Subject: New comments for application 19/01746/OUT

New comments have been received for application 19/01746/OUT at site address: Land Adj To Promised Land Farm Wendlebury Road Chesterton

## PROPOSED SURFACING PLAN

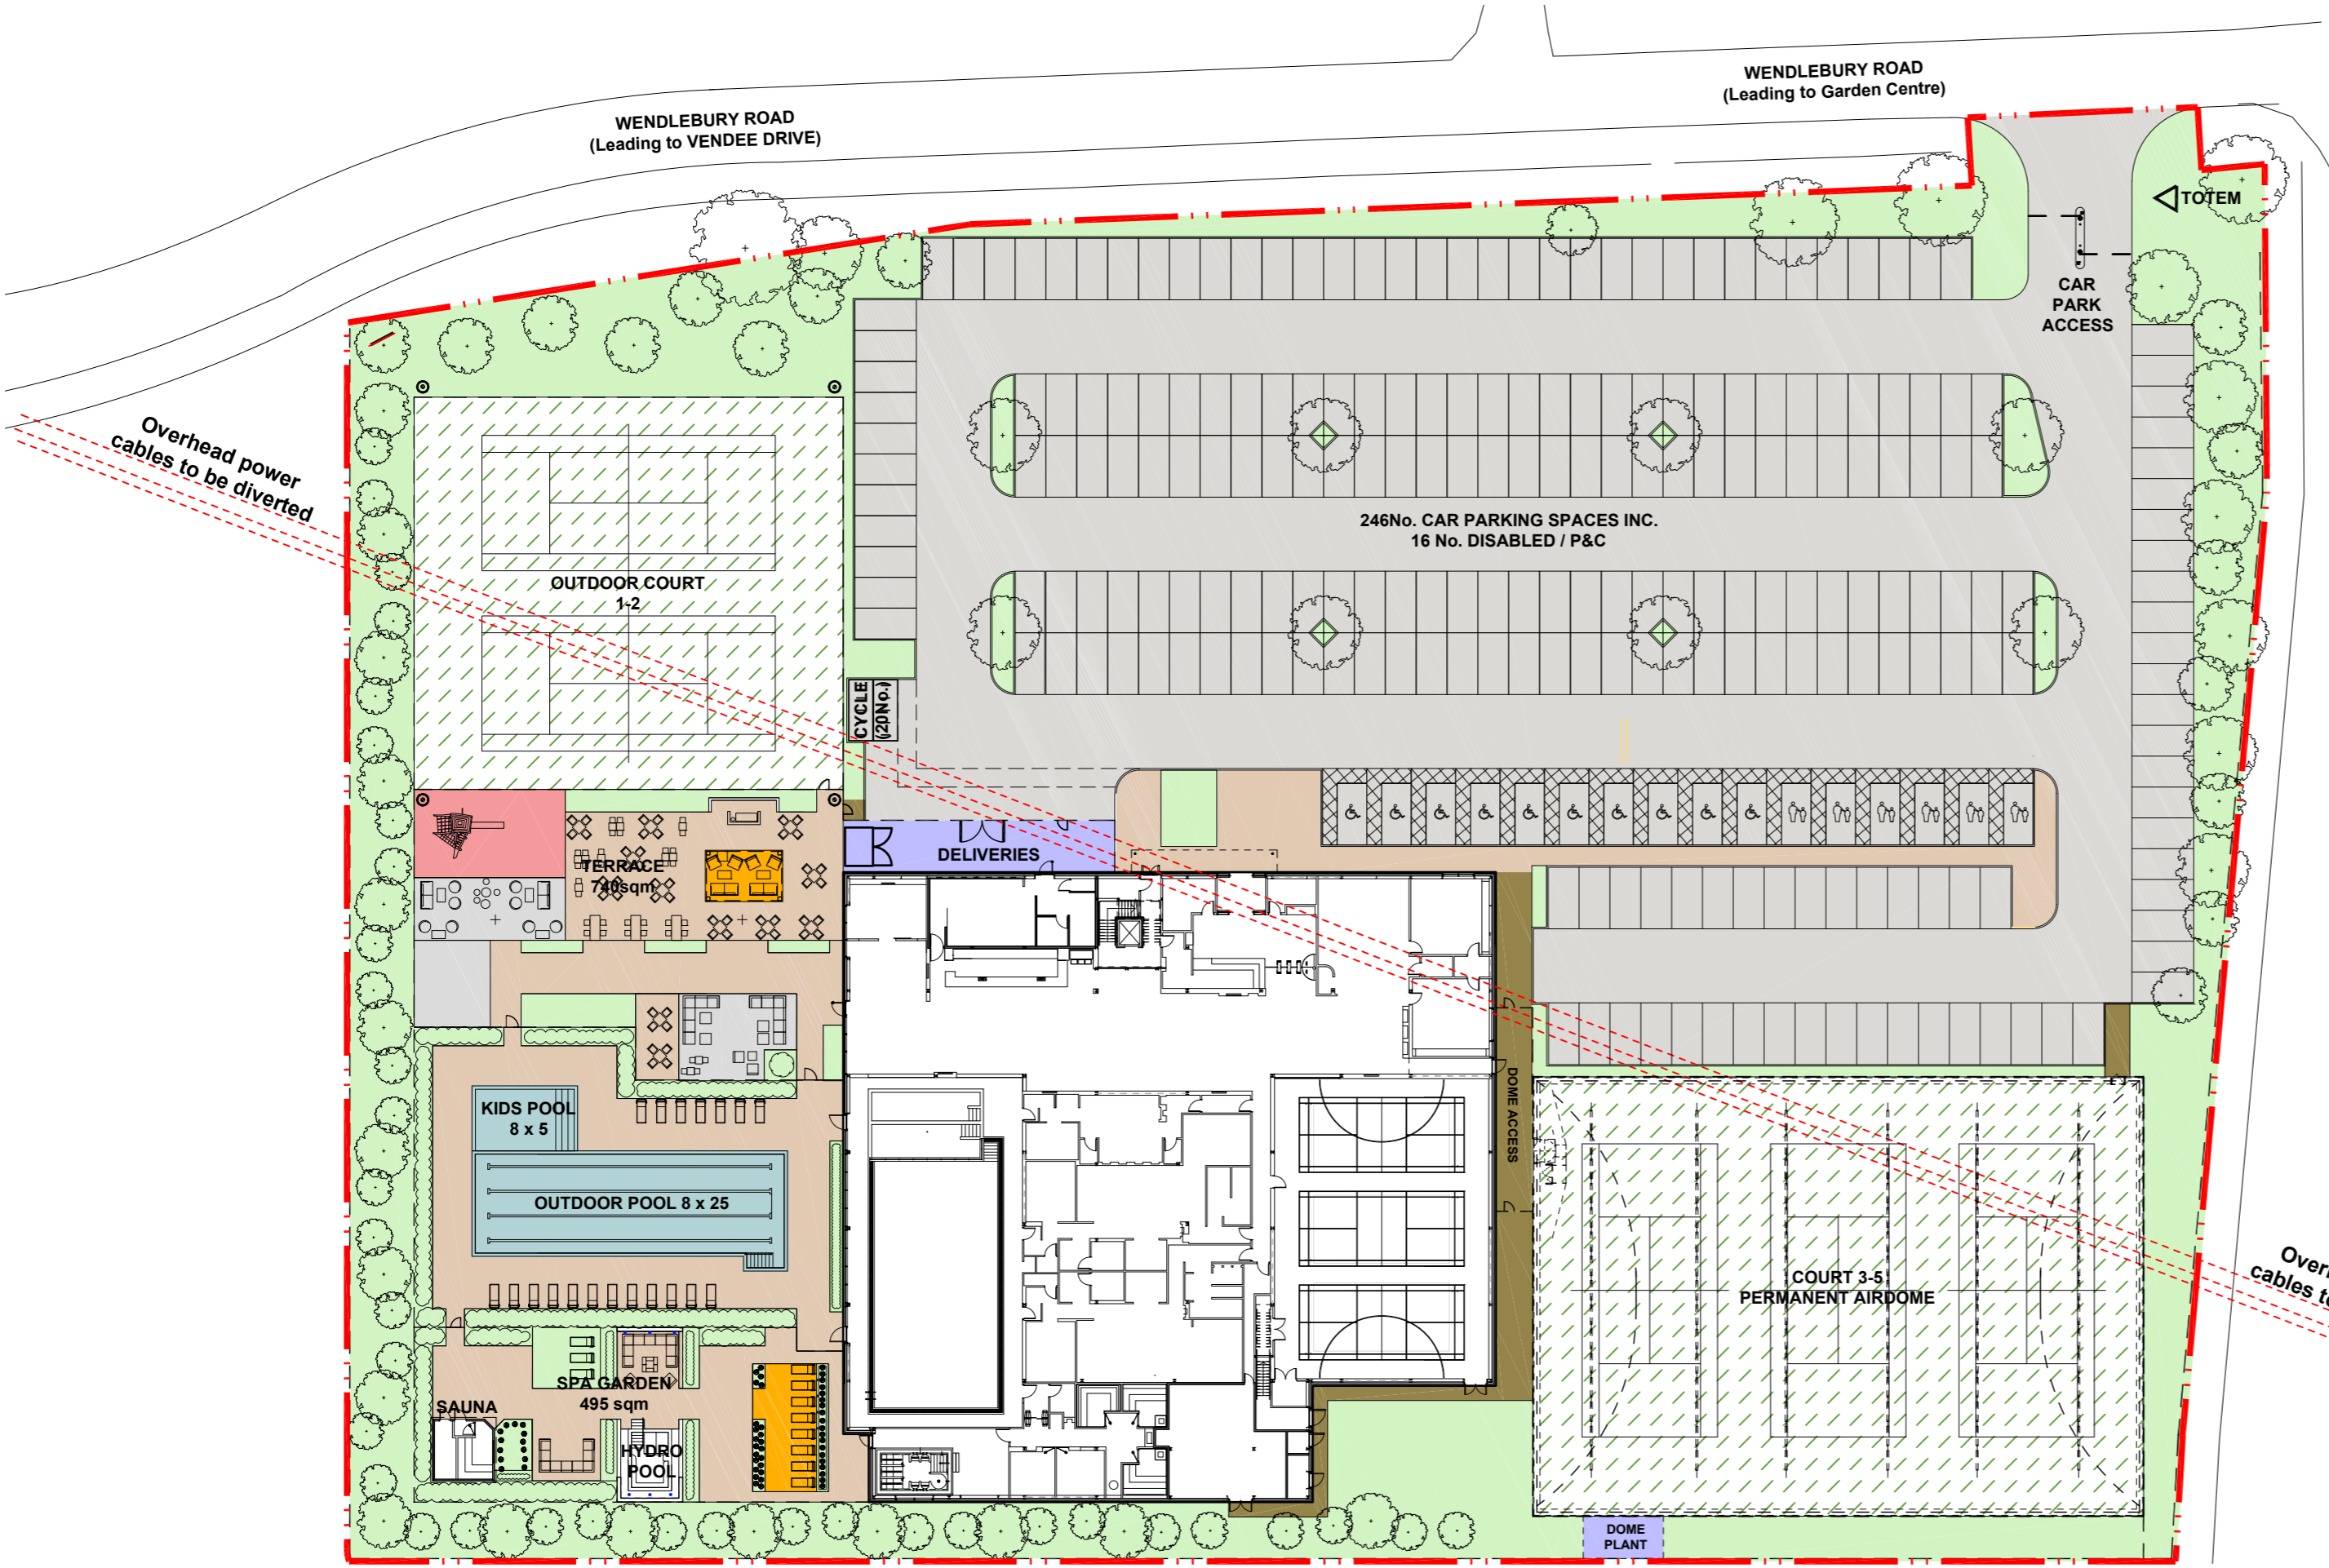
This plan for a new Business Park seems like a good project although it has several problems. First of all, the connection of the business park to the railway stations is not sufficient to ensure significant active travel, given the size of the business park and its impact this is the time to integrate it correctly into the active travel network. Improved infrastructure is required to ensure that active travel is possible from these main hubs. The plans claim to improve the cycling provision but in fact make break up the flow of cycle traffic with the side roads but providing only a mixed use path without priority. The proposals list 250 car parking spaces and only 20 cycle spaces, this shows insufficient ambition regarding active travel.

JOB TITLE		BICESTER CATALYST		CLIENT		ALBION LAND	
DRAWING TITLE							
WENDLEBURY ROAD SITE ACCESS ROUNDABOUT VEHICLE TRACKING							
SCALE	DRAWN BY	DATE	DRAWING No	REVISION			
1:250@A1	RJM	03/05/19	19539-11-03	A

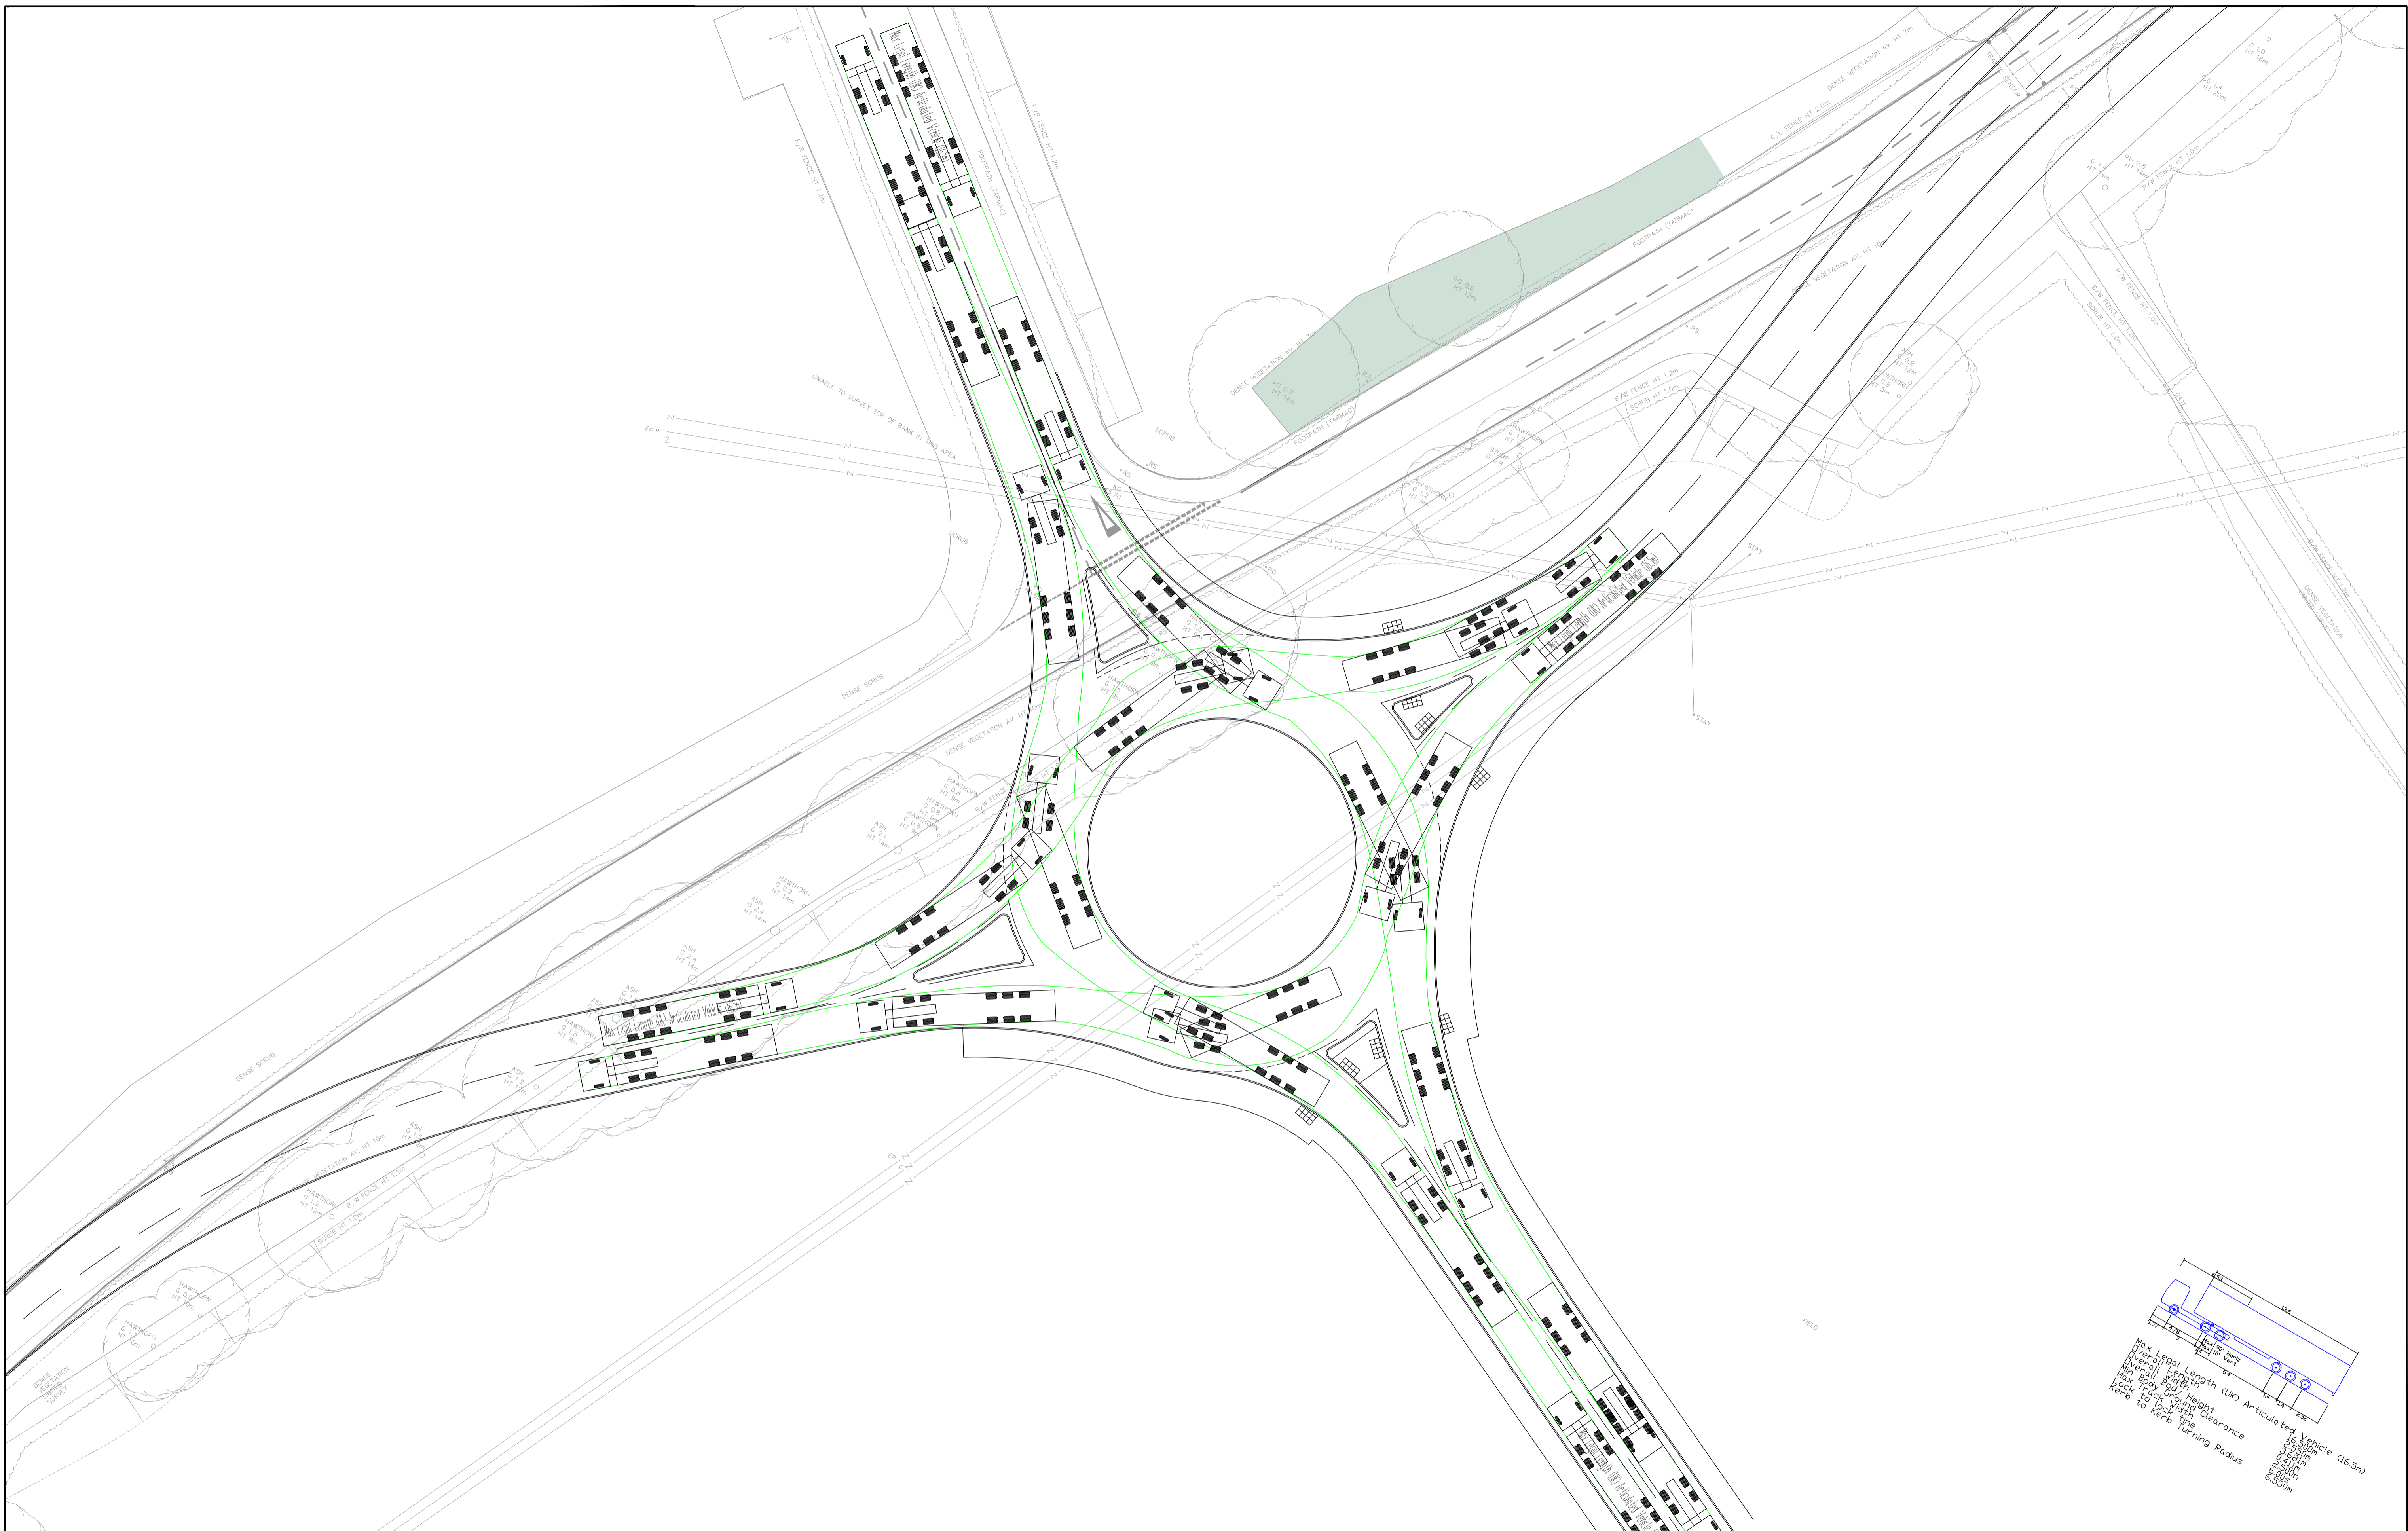
A segregated cycle path with priority over the adjoining roads in a 'dutch style' roundabout should be considered. Current plans show an access way to the leisure centre for all at the same point, this makes an unnecessary long route from some directions (e.g. the south and west). Additional access should be provided to ensure active travel is not hindered. A similar 'multi access for active travel' approach should be taken across the development.
